Re: Section 73 Variation of condition application to planning consent SDNP/22/05710/FUL dated 18th May 2023– Erection of 20 pre-fabricated glamping pods and associated footpaths, retrospective alterations to previously consented raised timber decking adjacent to driving range with addition of pergola and associated alterations, and erection of pergolas over clubhouse rear patio at: Blacknest Golf & Country Club, Frith End Road, Blacknest, GU34 4QL

Please find enclosed a section 73 Variation of Condition application for minor material amendments to planning consent SDNP/22/05710/FUL.

REV	DATE	DESCRIPTION	DRAWN
CLIENT			
360 BEECH			
PROJECT			
BLACKNEST GOLF CLUB			
FRITH END ROAD, BLACKNEST			
DRAWING TITLE			
PROPOSED NOKKEN POD - 01			
STATUS			
SKETCH			
PROJECT No	DWG TYPE	DWG No	REV
2639	SK	601	00
SCALE	DATE	DRAWN	CHECKED
1:200@A3	JAN 24	JW	DL

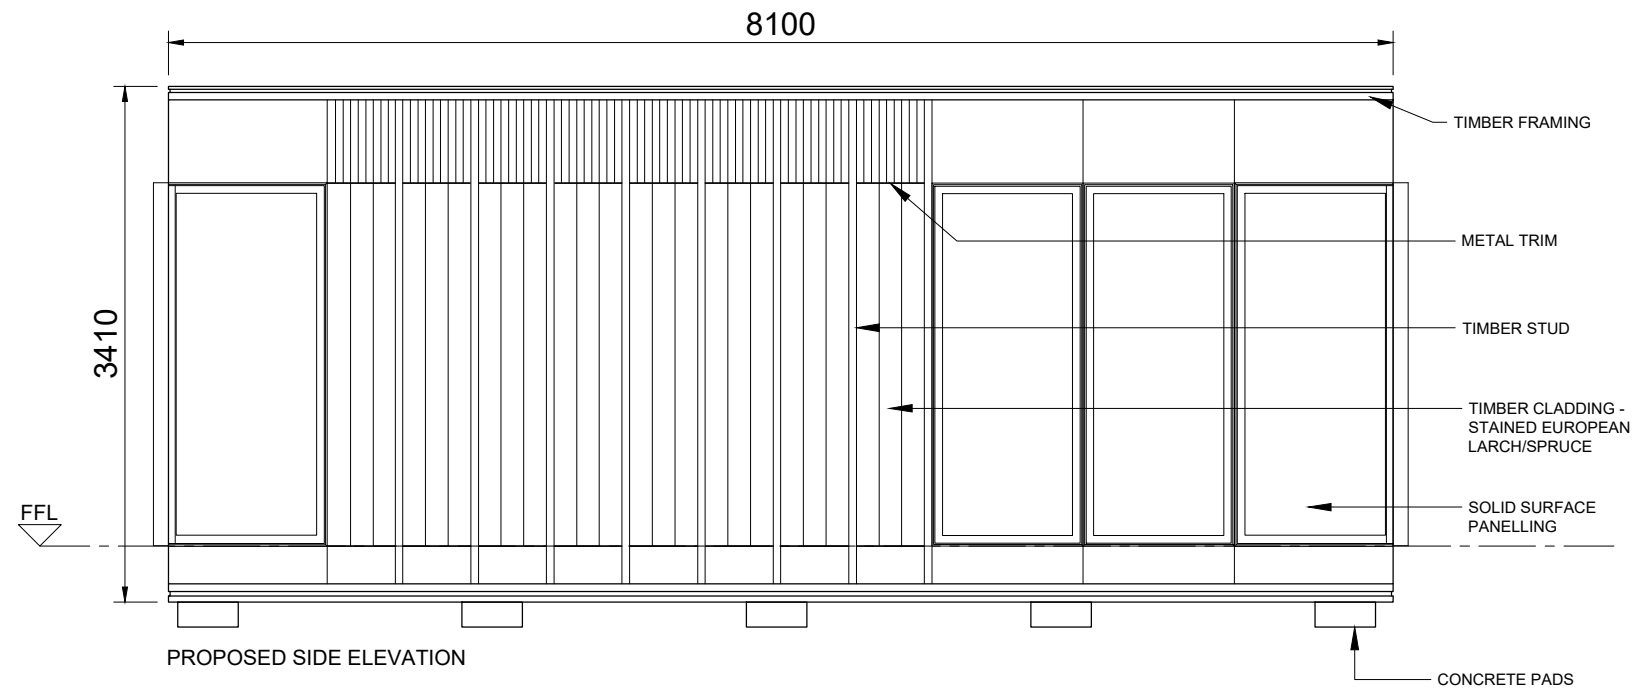
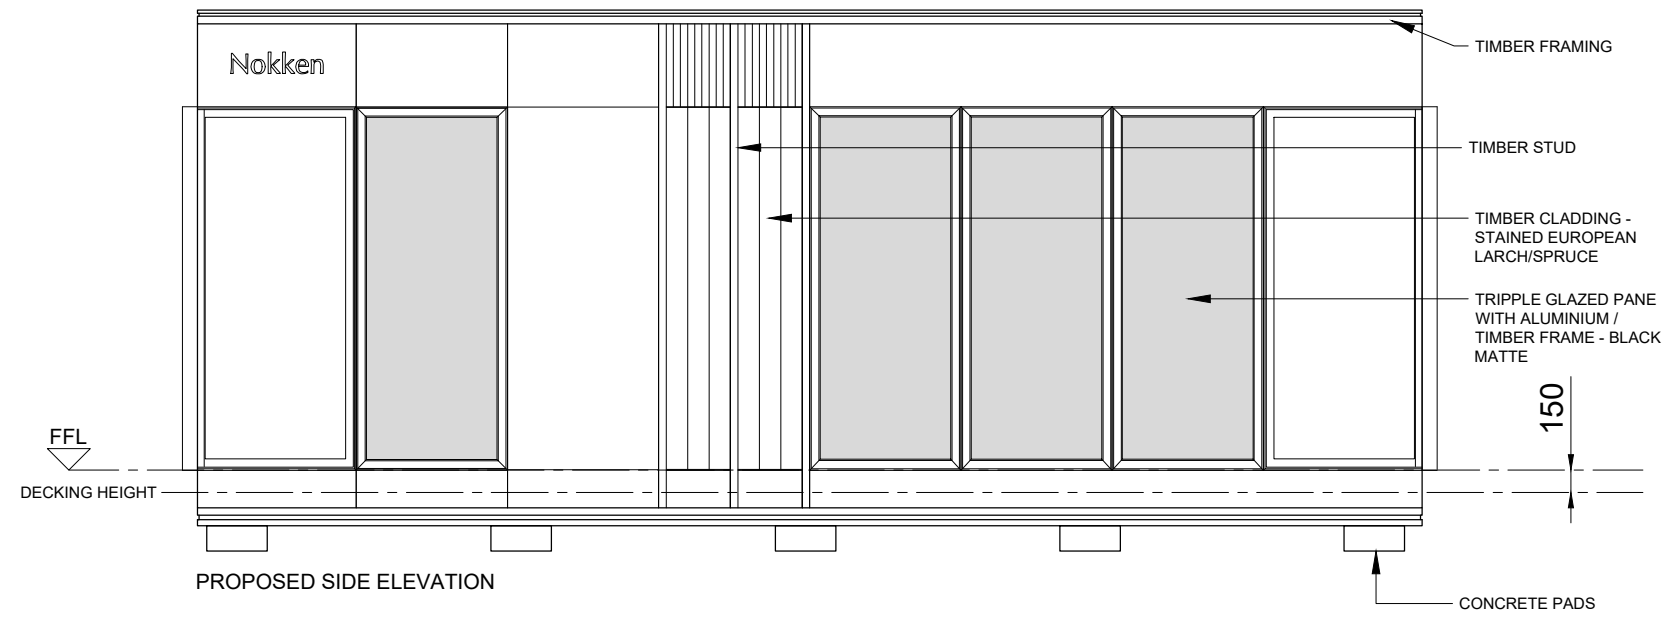
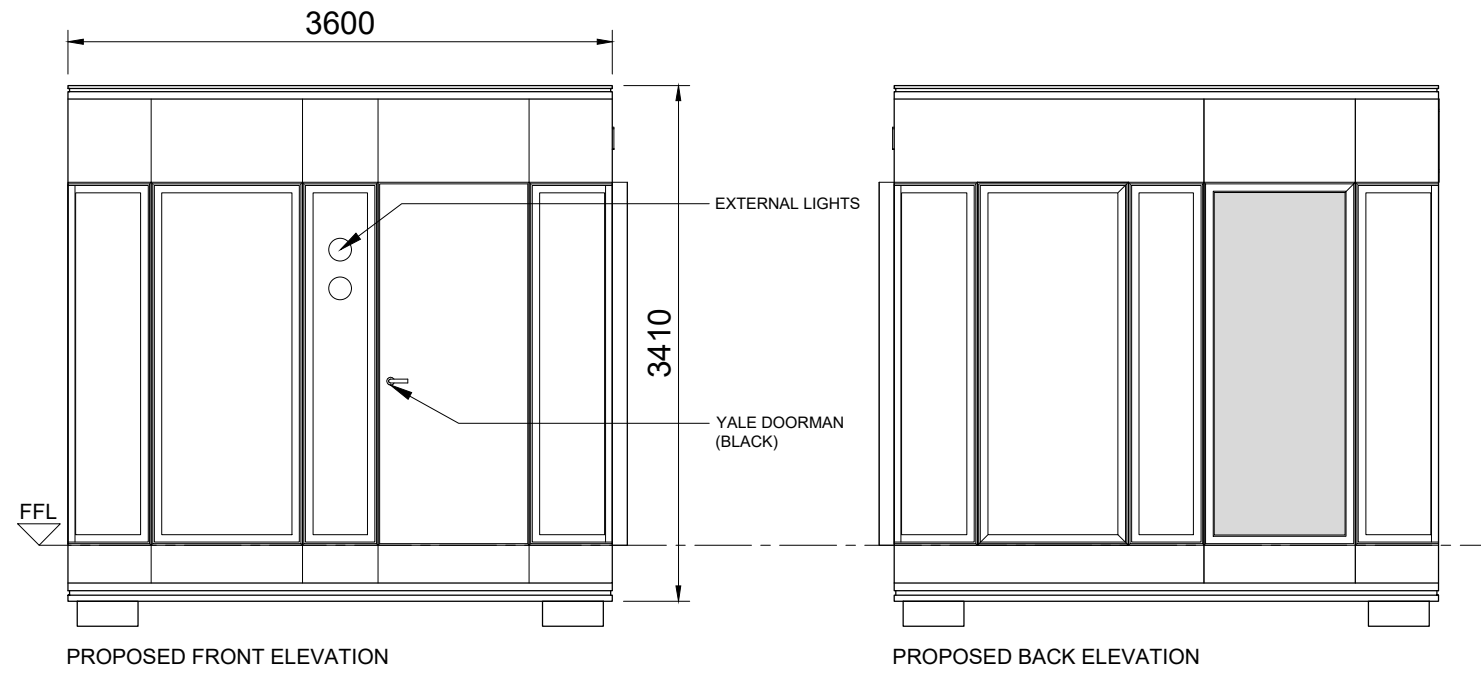
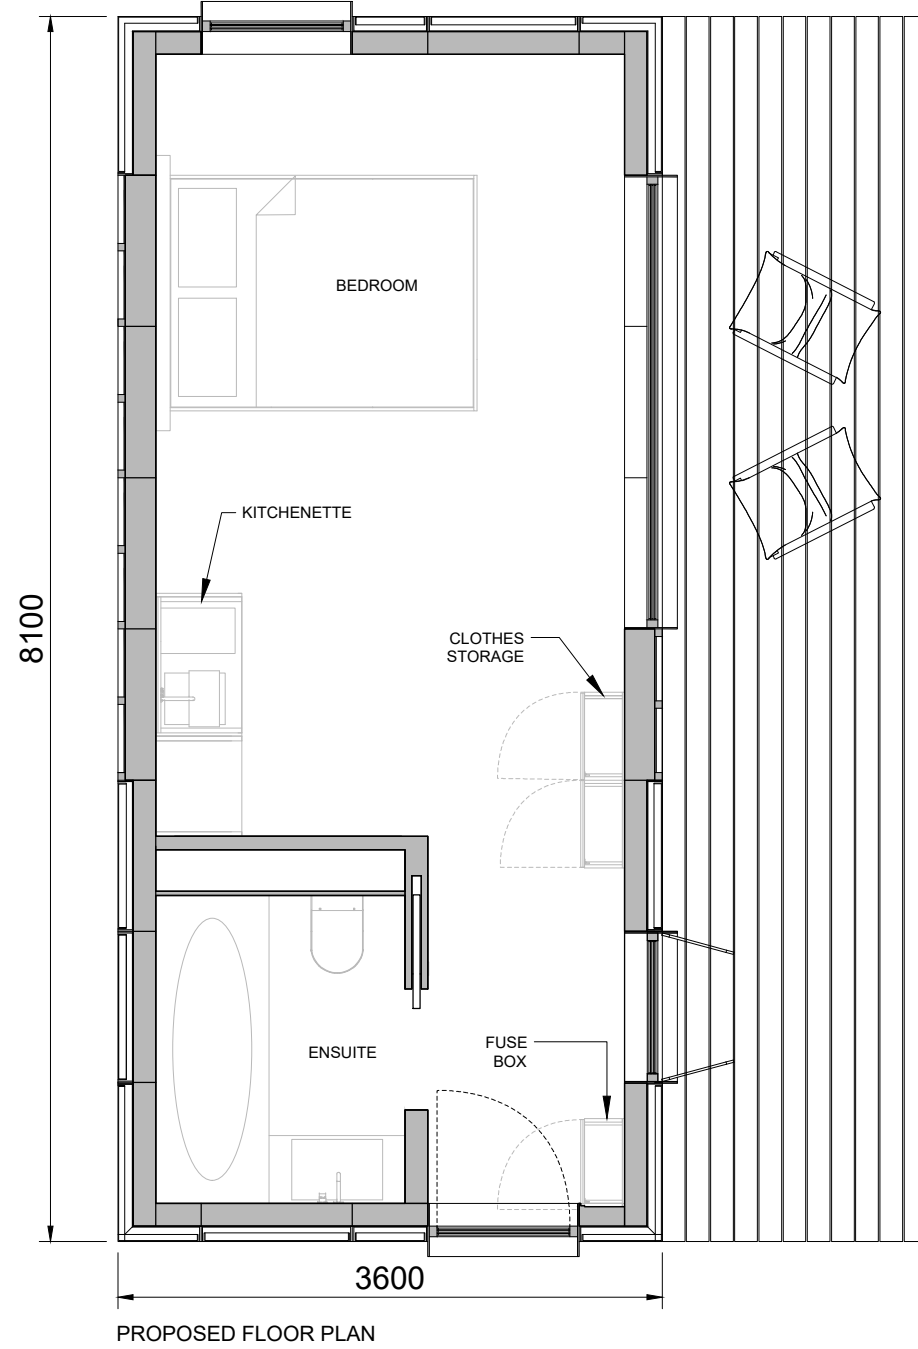
- Replacing the cabins with an alternative cabin manufacturer in similar locations.
- And, insignificant minor alterations to the associated paths and landscaping layout adjacent to the cabins to accommodate the new cabin types due to the positioning of their front doors.

- This condition is to be amended to replace the proposed drawings and documentation to allow use of a different manufacturer and type of cabin, with associated alterations to the paths, landscaping etc to accommodate the minor changes in size and positioning of the cabins.
